Rezoning Transportation Analysis

Petition Number: #2022-183

Date	Description
03-23-23	First Review (PDM)
04-20-23	Second Review (PDM)
05-24-23	Third Review (PDM)
07-26-23	Fourth Review (PDM)

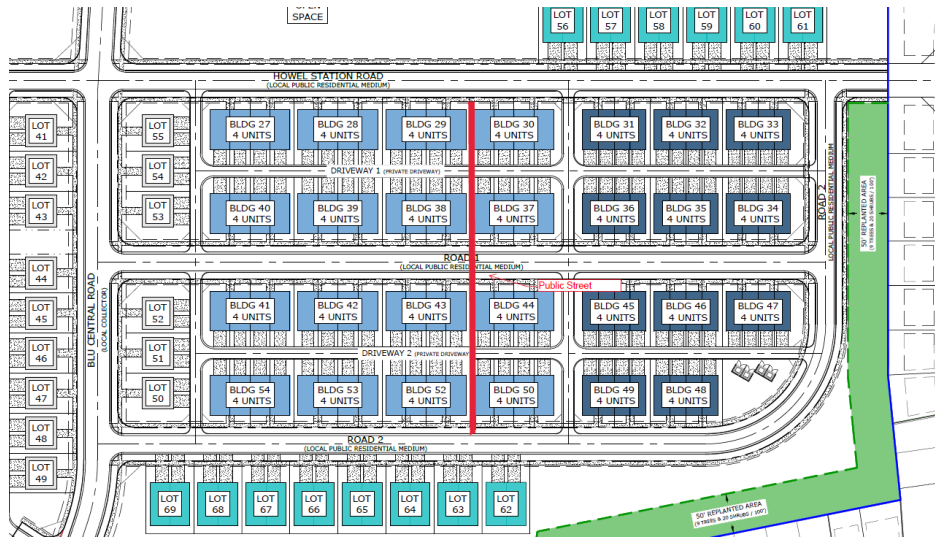
8. ~~Comment rescinded based on revised site plan from 04-20-23:~~ Revise site plan to clarify Ervin Lane roadway tie in and end the public portion of the street at Blu Central Road

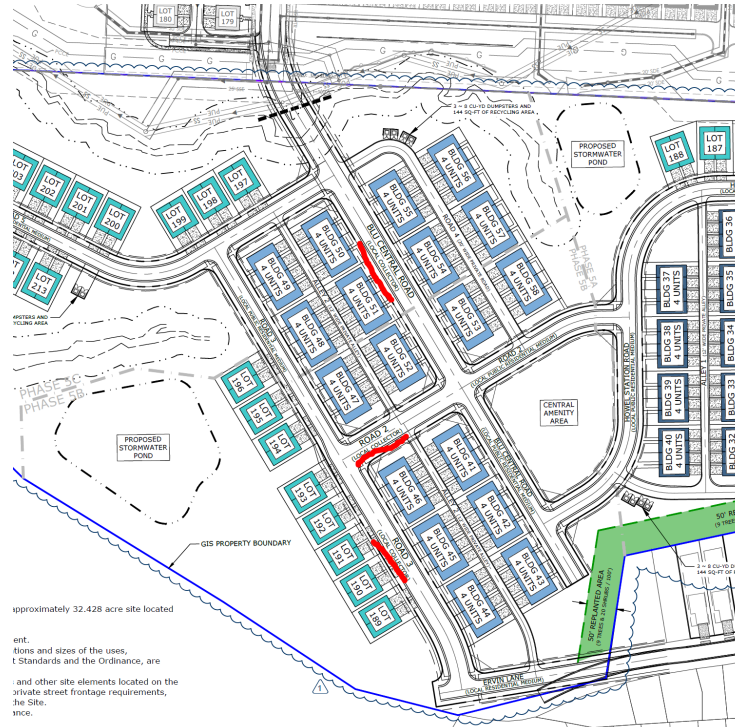
This note
does not
match
development
phasing

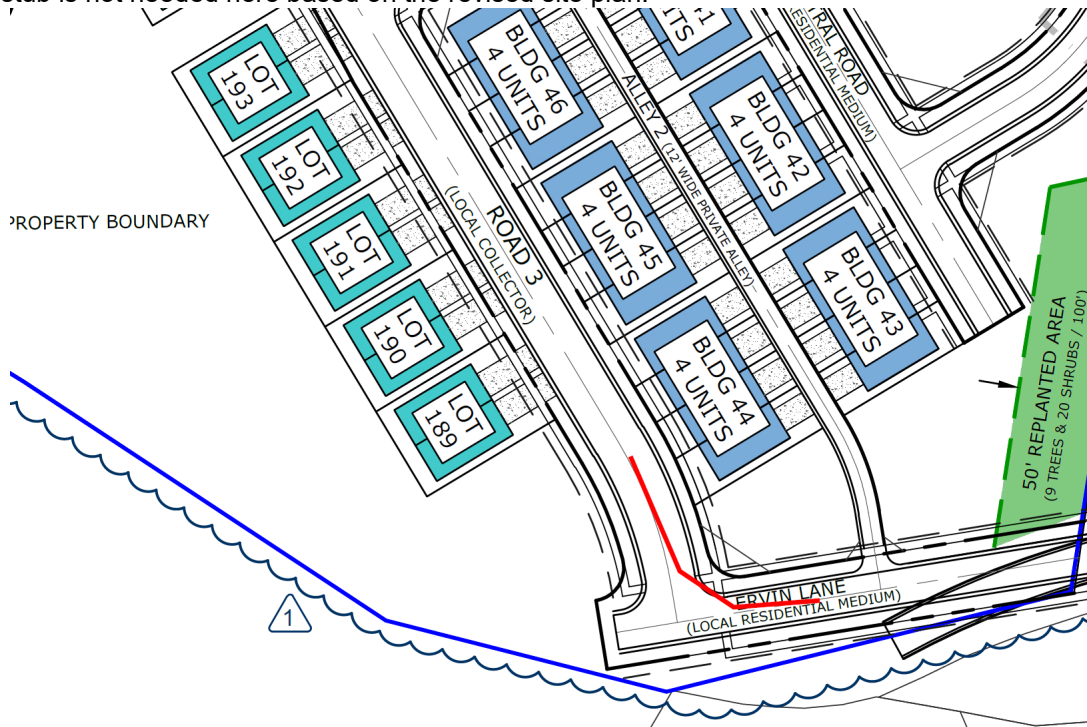
11. ~~Outstanding Comment from 4.20.2023 Revised Site Plan: Revise site plan to provide a single continuous collector street (Blu Central Road) to Ervin Road. The collector street shall meet CDOT design standards.~~
